CITY OF ALBUQUERQUE

January 24, 2018

Re: Kalm Brewery
8338 Comanche Rd NE
Traffic Circulation Layout
Engineer's/Architect's Stamp **01-04-18** (G19-D040)

TRAFFIC CIRCULATION LAYOUT

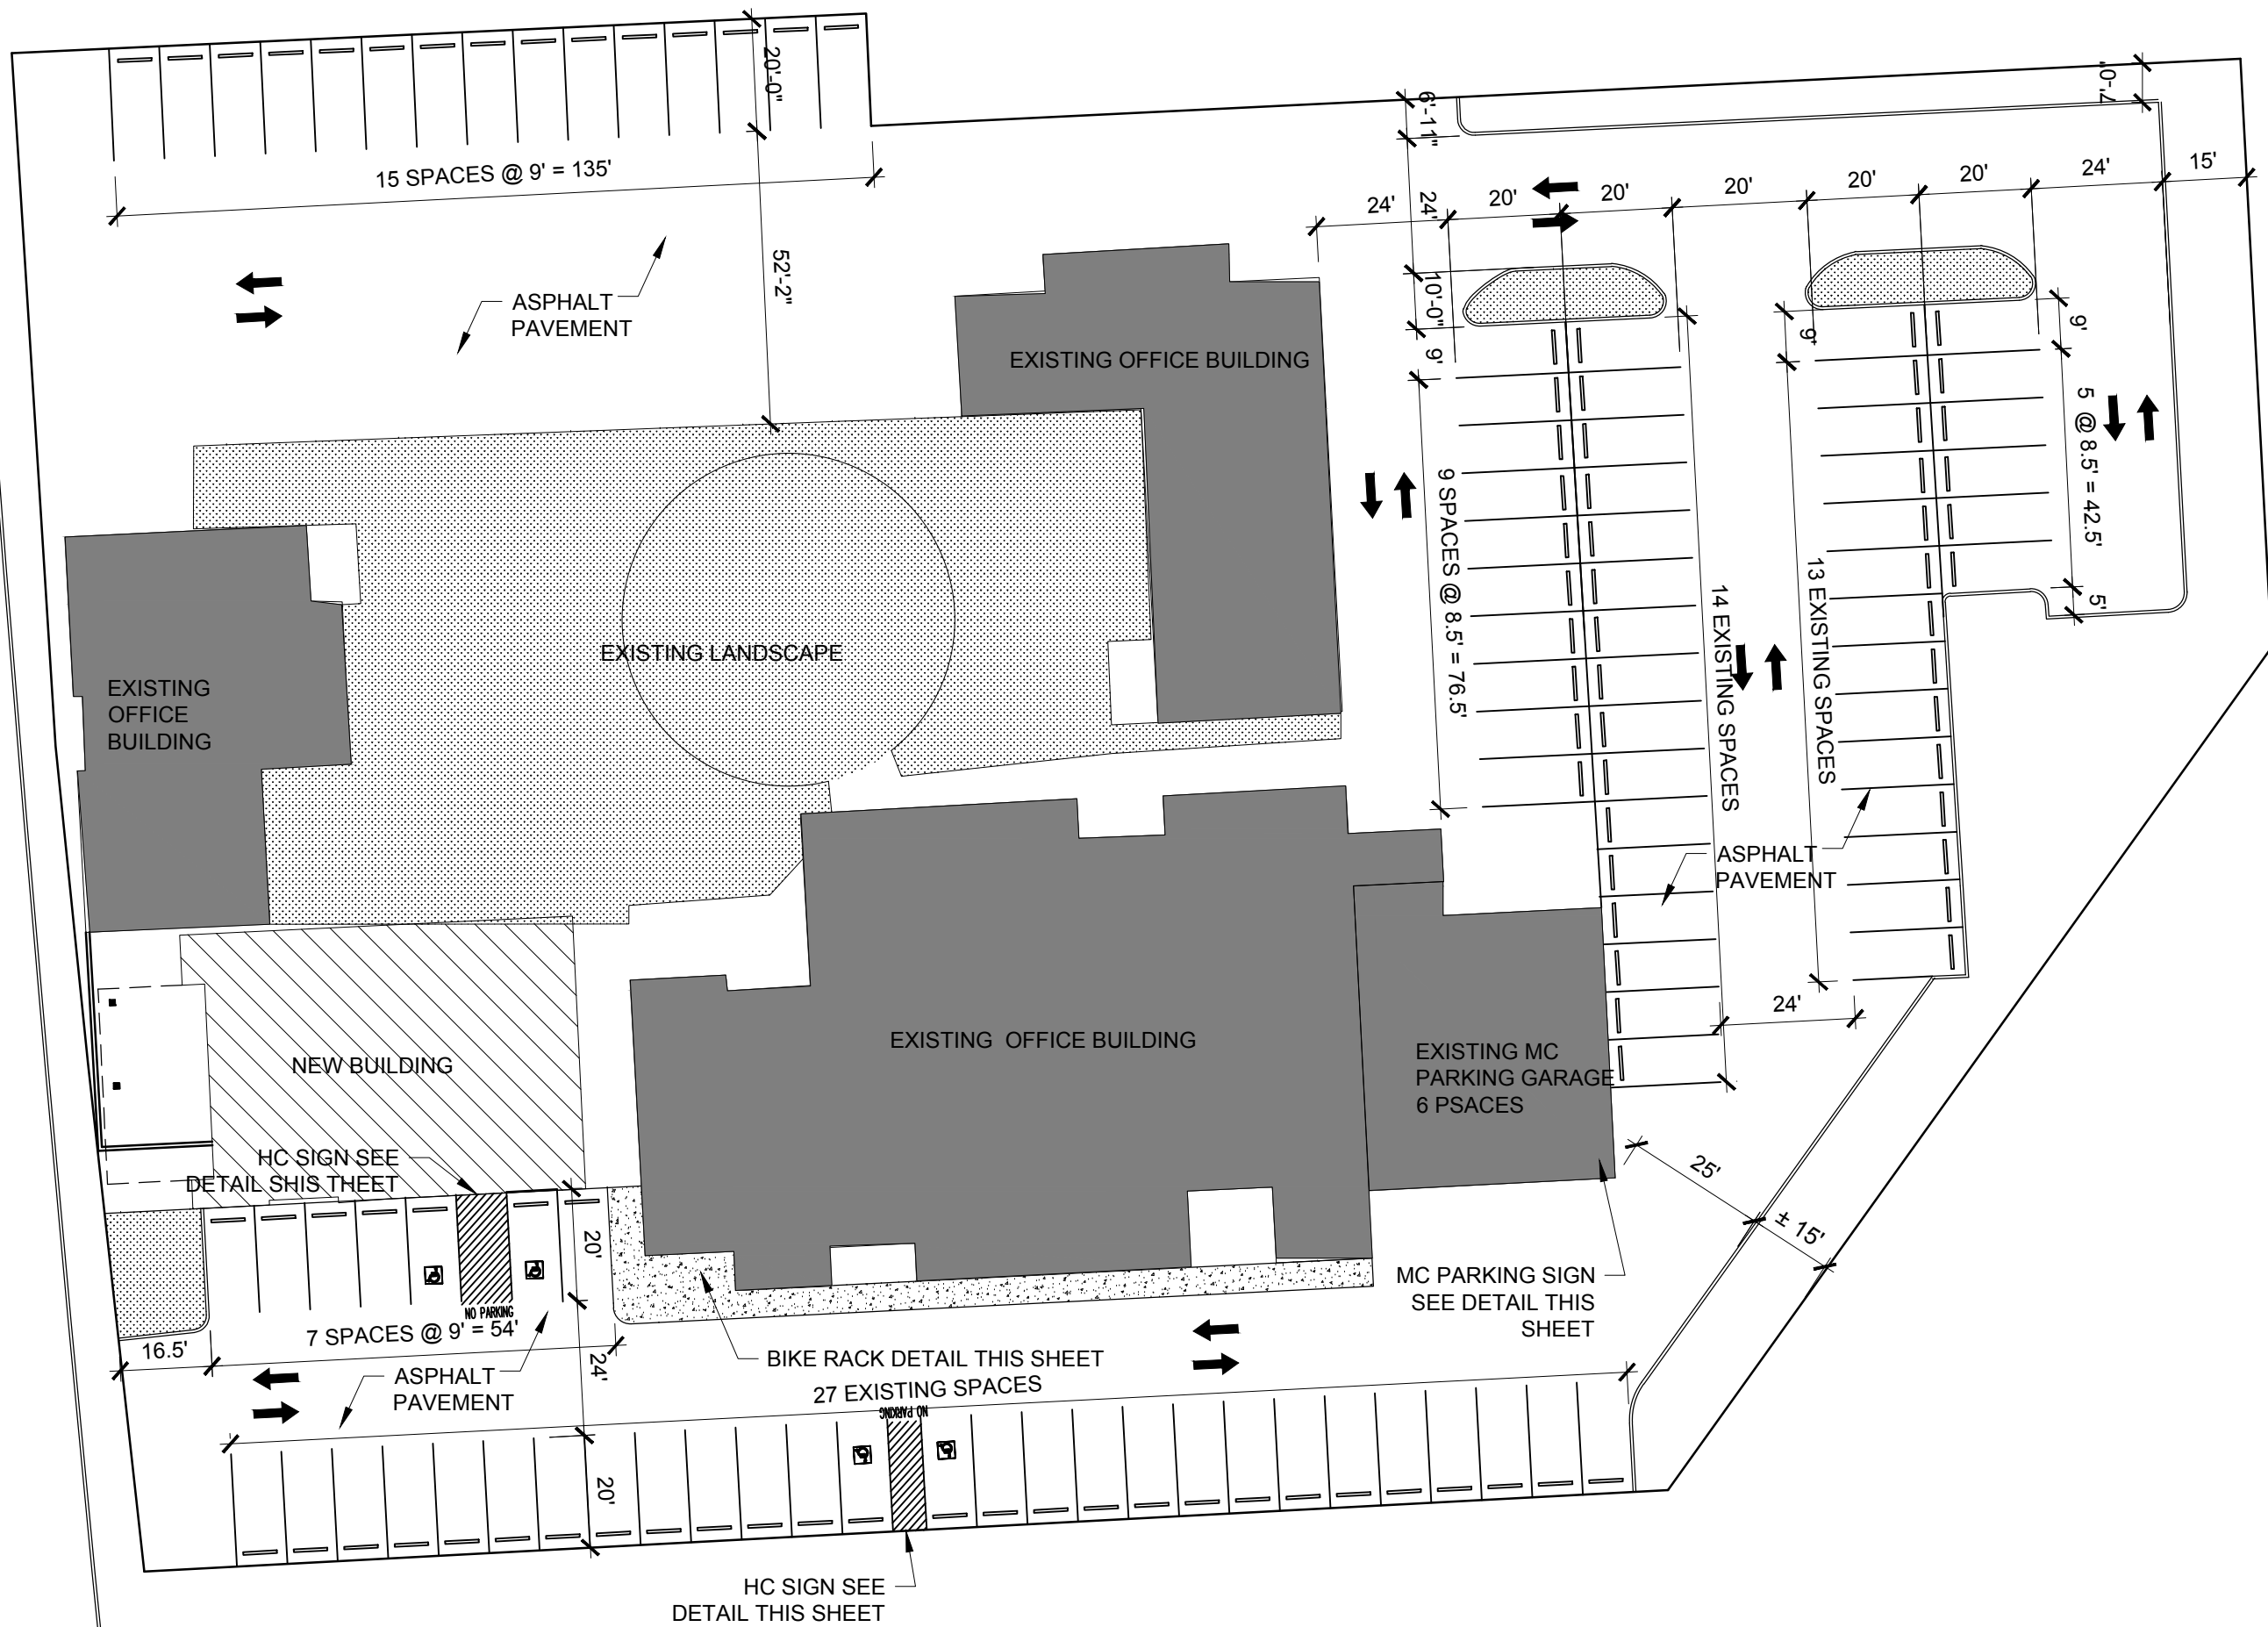
3. Please show a vicinity map showing the location of the development in relation to streets and well known landmarks.
4. List the number of accessible parking spaces required by the zoning code with the parking calculations.

5. A scale of 1"=20' is recommended for sites less than 5 acres.
6. Please remove the topo information and the adjacent parcels not related to the building permit.

7. Please identify all existing buildings, doors, structures, sidewalks, curbs, drive pads, wall and anything that influences the parking and circulation on the site.

8. Identify the right of way width, medians, curb cuts, and street widths on Comanche.
9. Clarify existing property lines and proposed property lines.
10. Please list the width and length for all existing and proposed parking spaces. Some dimensions are not shown.

15. Show all drive aisle widths and radii. Some dimensions are not shown.
16. The parking spaces on the south end do not look to be useable. All spaces on the site plan must be present and functional, at final inspection.

17. List radii for all curves shown; for passenger vehicles, the minimum end island radius for passenger vehicles is 15 ft. Radius for delivery trucks, fire trucks, etc. is 25 ft. or larger.

18. Per the zoning code, a 6 ft. wide ADA accessible pedestrian pathway is required from the public sidewalk to the building entrances. Please clearly show this pathway and provide details.

19. Per DPM, a 6 ft. wide ADA accessible pedestrian pathway is required from the HC parking stall access aisles to the building entrances. Please clearly show this pathway and provide details.

MC PARKING SIGN

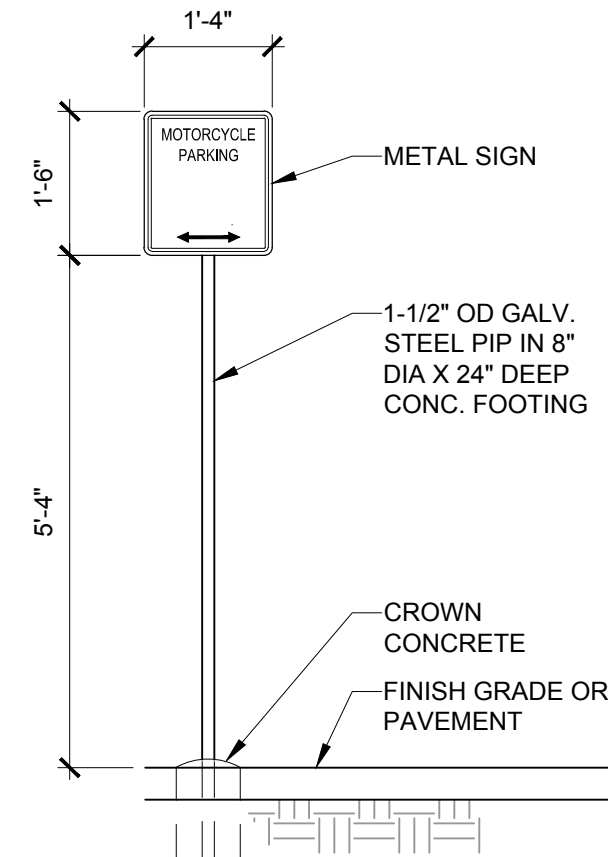
14. Motorcycle parking spaces shall be designated by its own conspicuously posted upright sign, either free-standing or wall mounted per the zoning code.

C6 HC PARKING SIGN

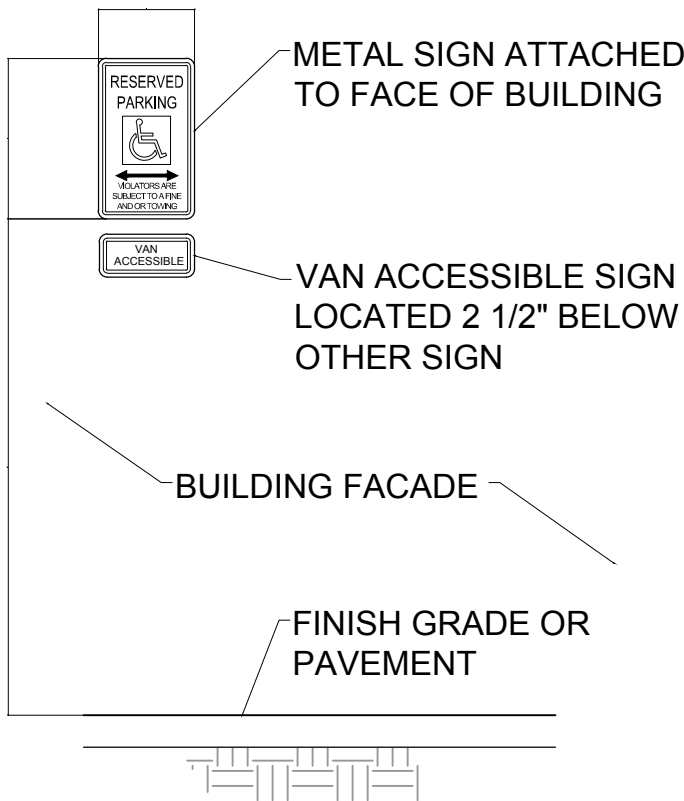
11. The ADA accessible parking spaces must be updated to current ADA standards.
12. The ADA accessible parking sign must have the required language per 66-7-352.4C NMSA 1978 **"Violators Are Subject to a Fine and/or Towing."** Please call out detail and location of HC signs.
